3.4 CHILD CARE

3.5 BUILDING HEIGHT

## SICEEP - Darling Square Shadow Study

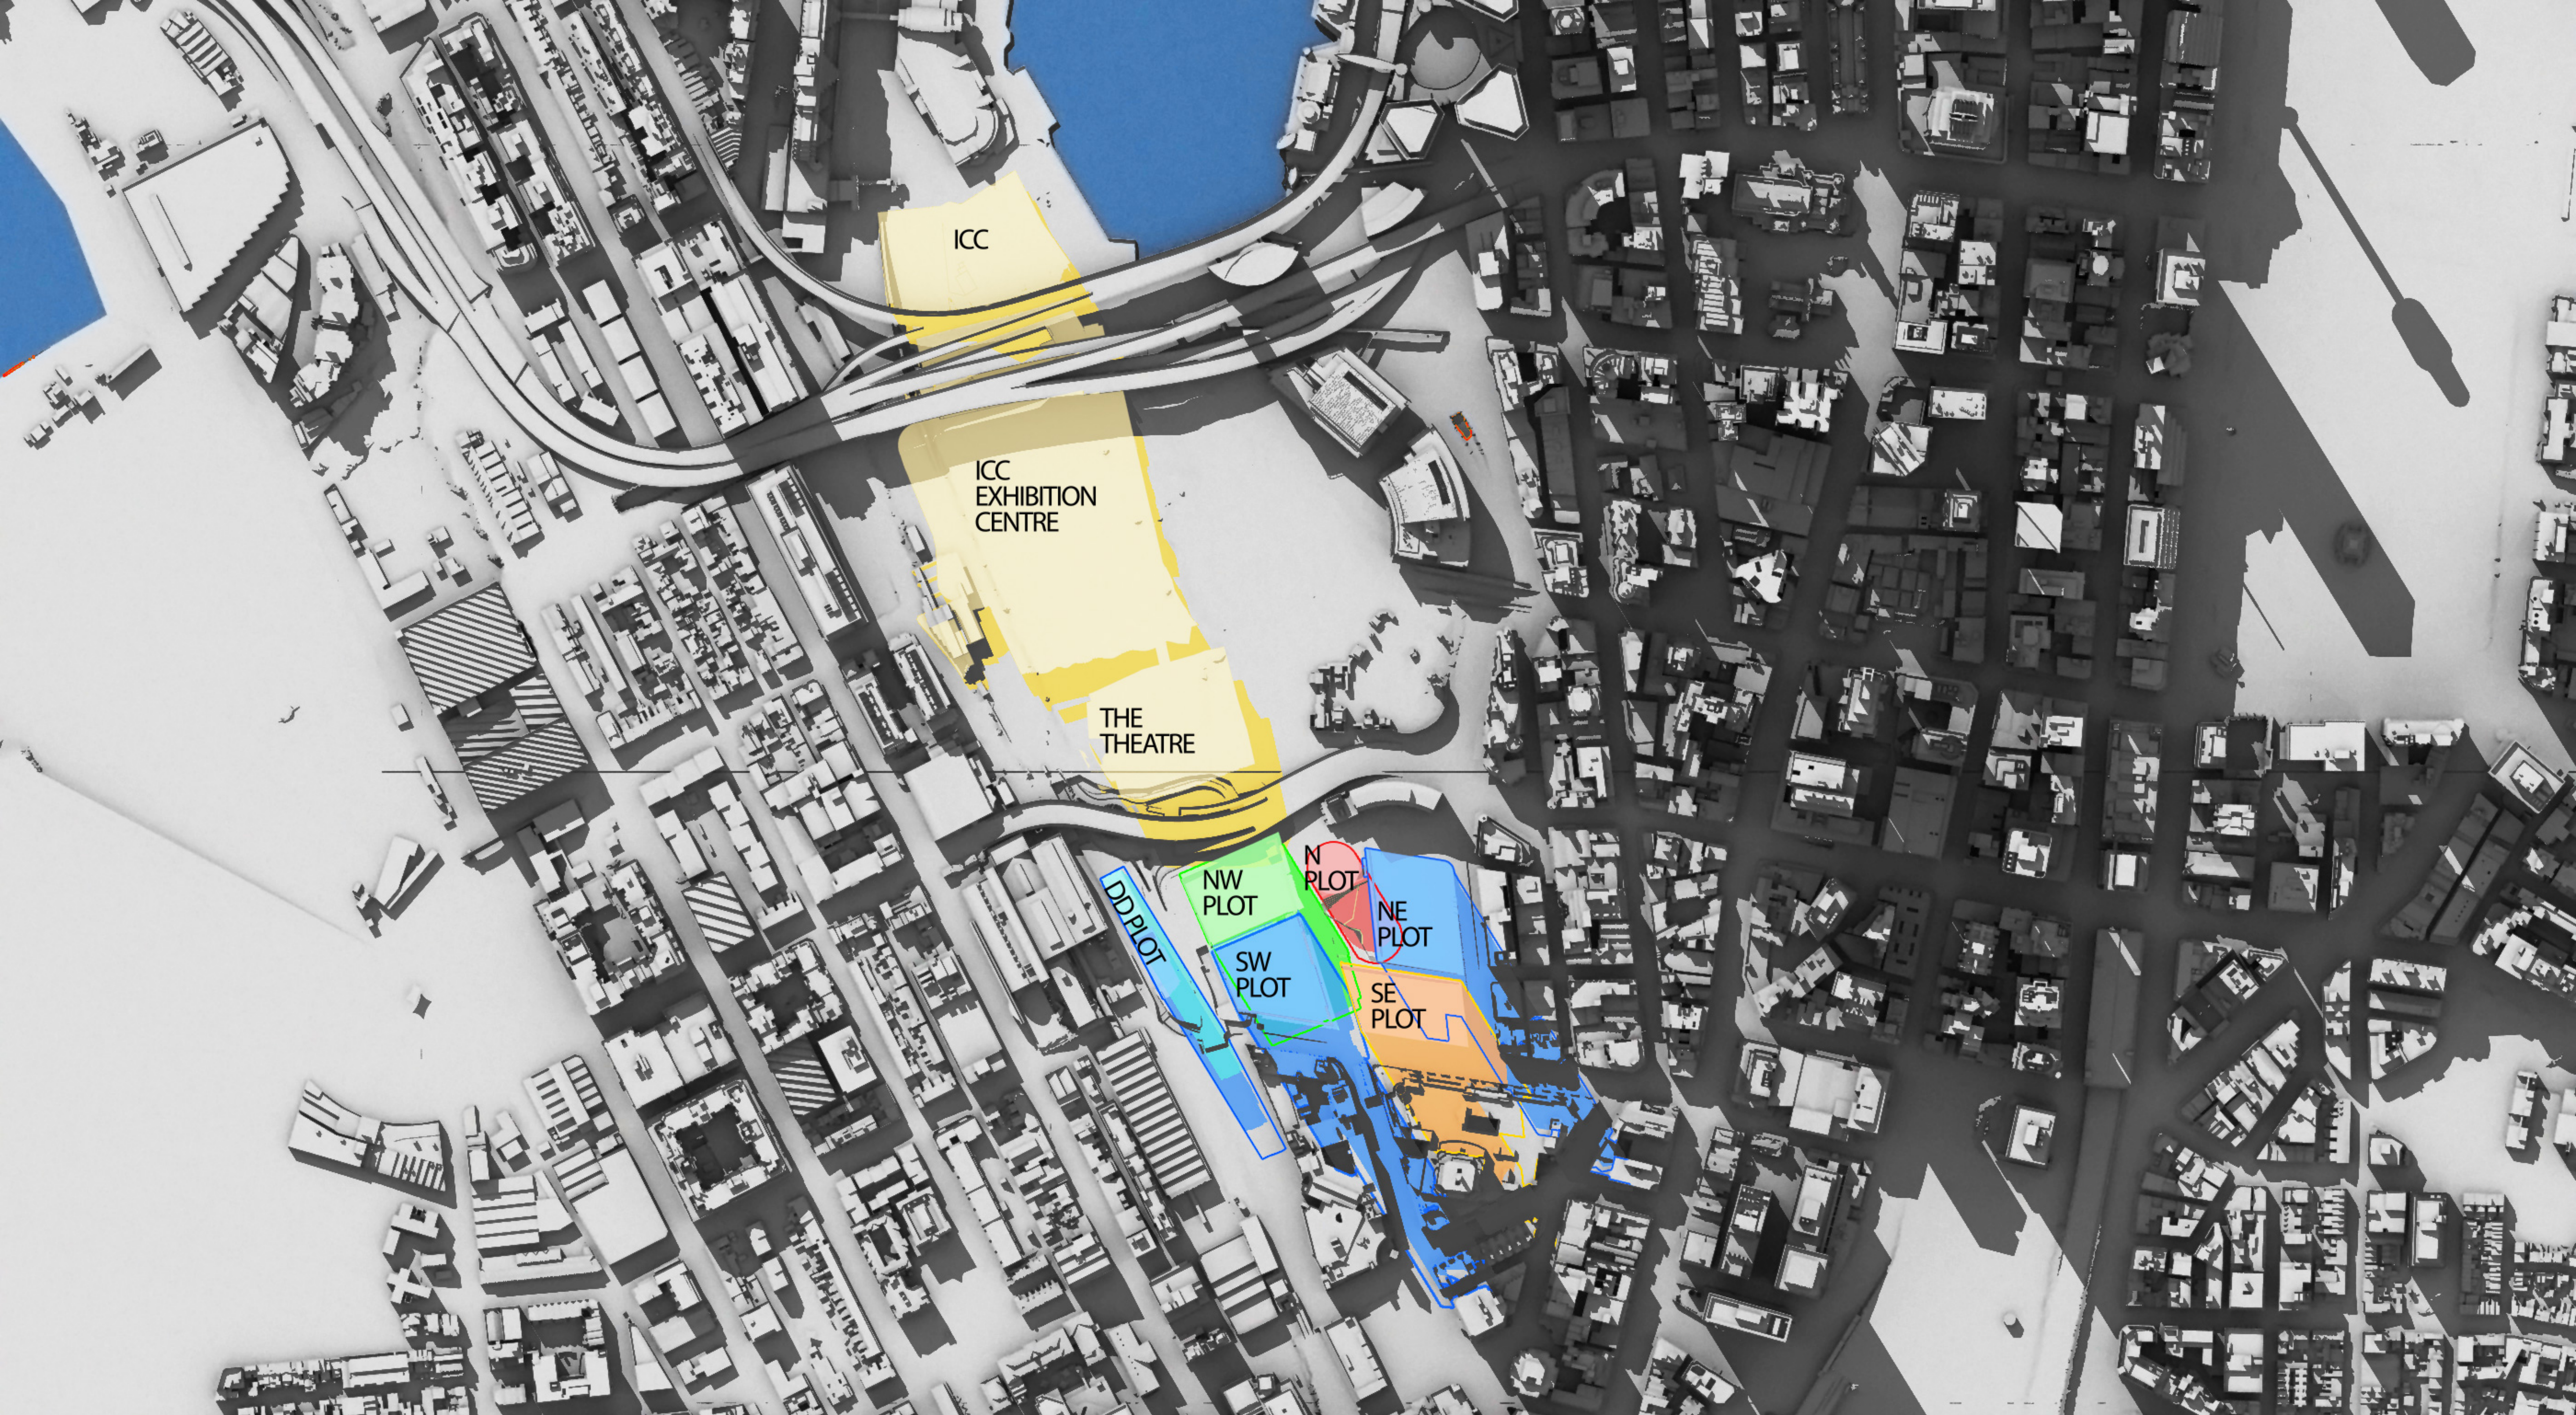
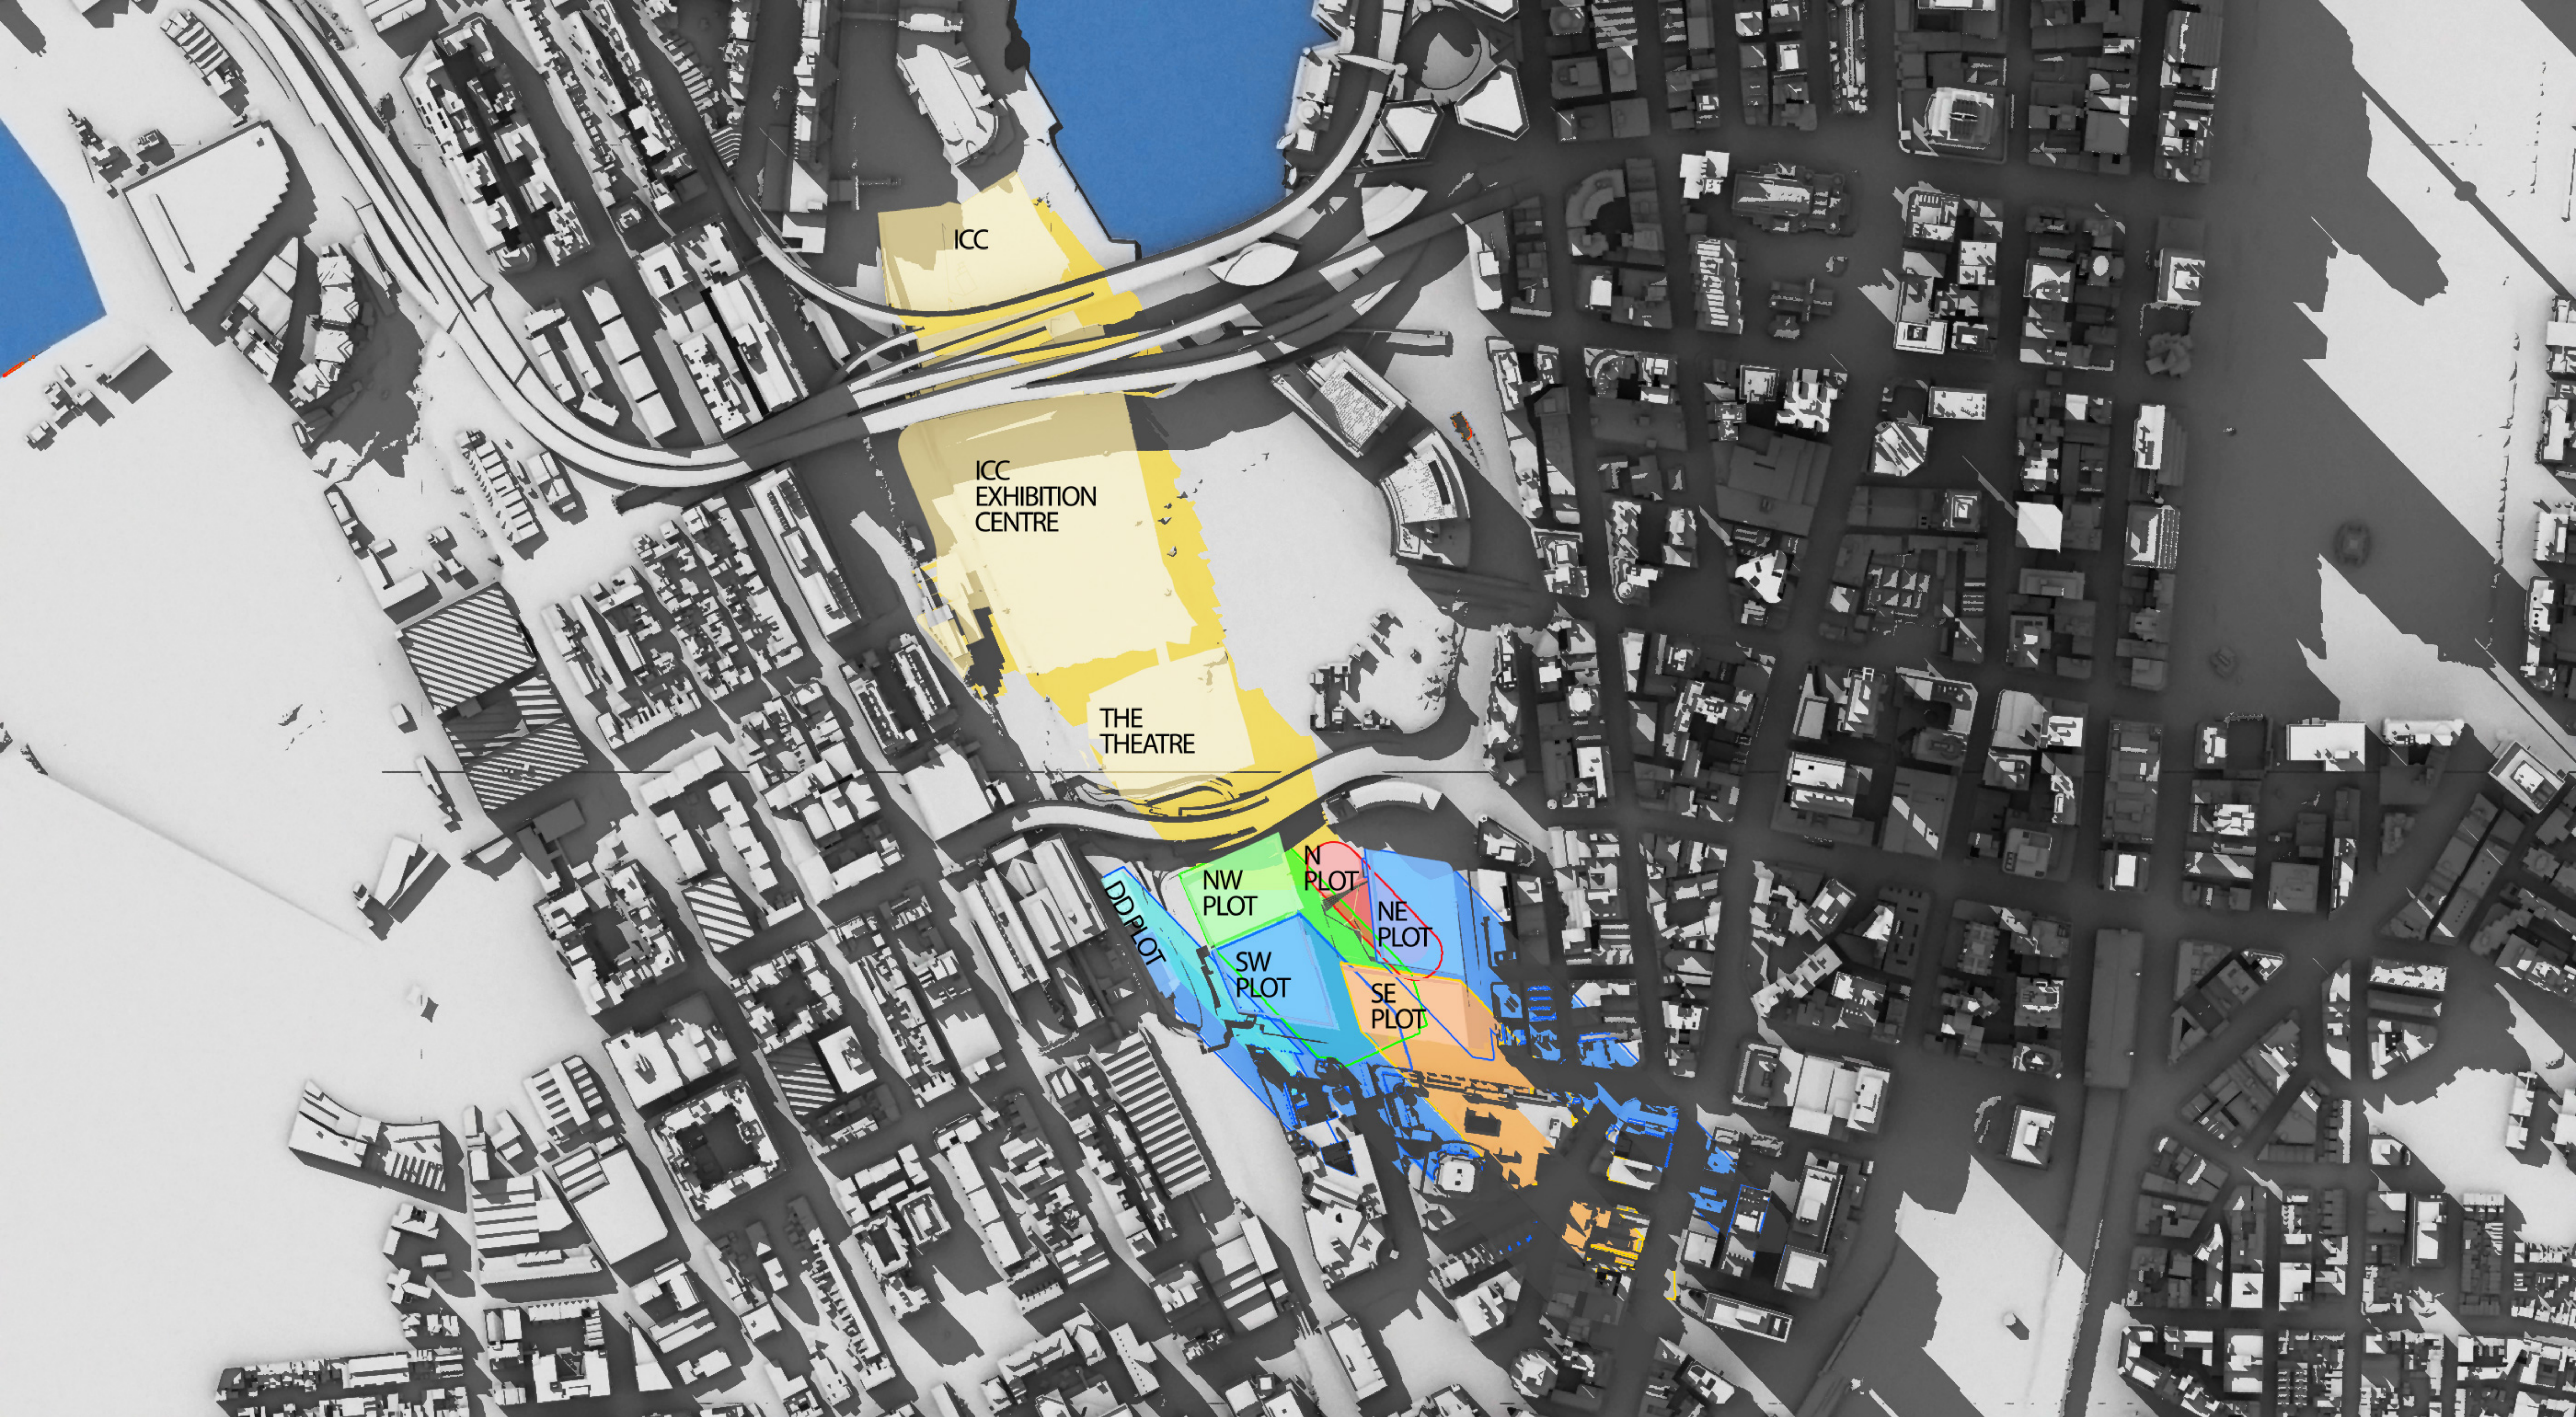
The Authority notes that the height of the proposed building (Darling Exchange) on the North Plot has increased by 5 metres. Any increase in building height should not create additional overshadowing across Haymarket Square during mid-winter. Further modelling is considered necessary in order to ensure solar access across Haymarket Square is maximised, especially the critical 12 midday to 2.00pm lunch time period during mid-winter and to confirm that the built form of the Darling Exchange does not dominate the public square.

The impact from the 5m increase in height has been assessed in great detail as part of the S96 modification to the Concept Plan which has now been approved. The building is entirely within this parameter plan and consistent with the overall parameter plan height control.

The building has been positioned to minimise the shadowing throughout the year. Refer to Appendix B - Shadow Analysis for further information.
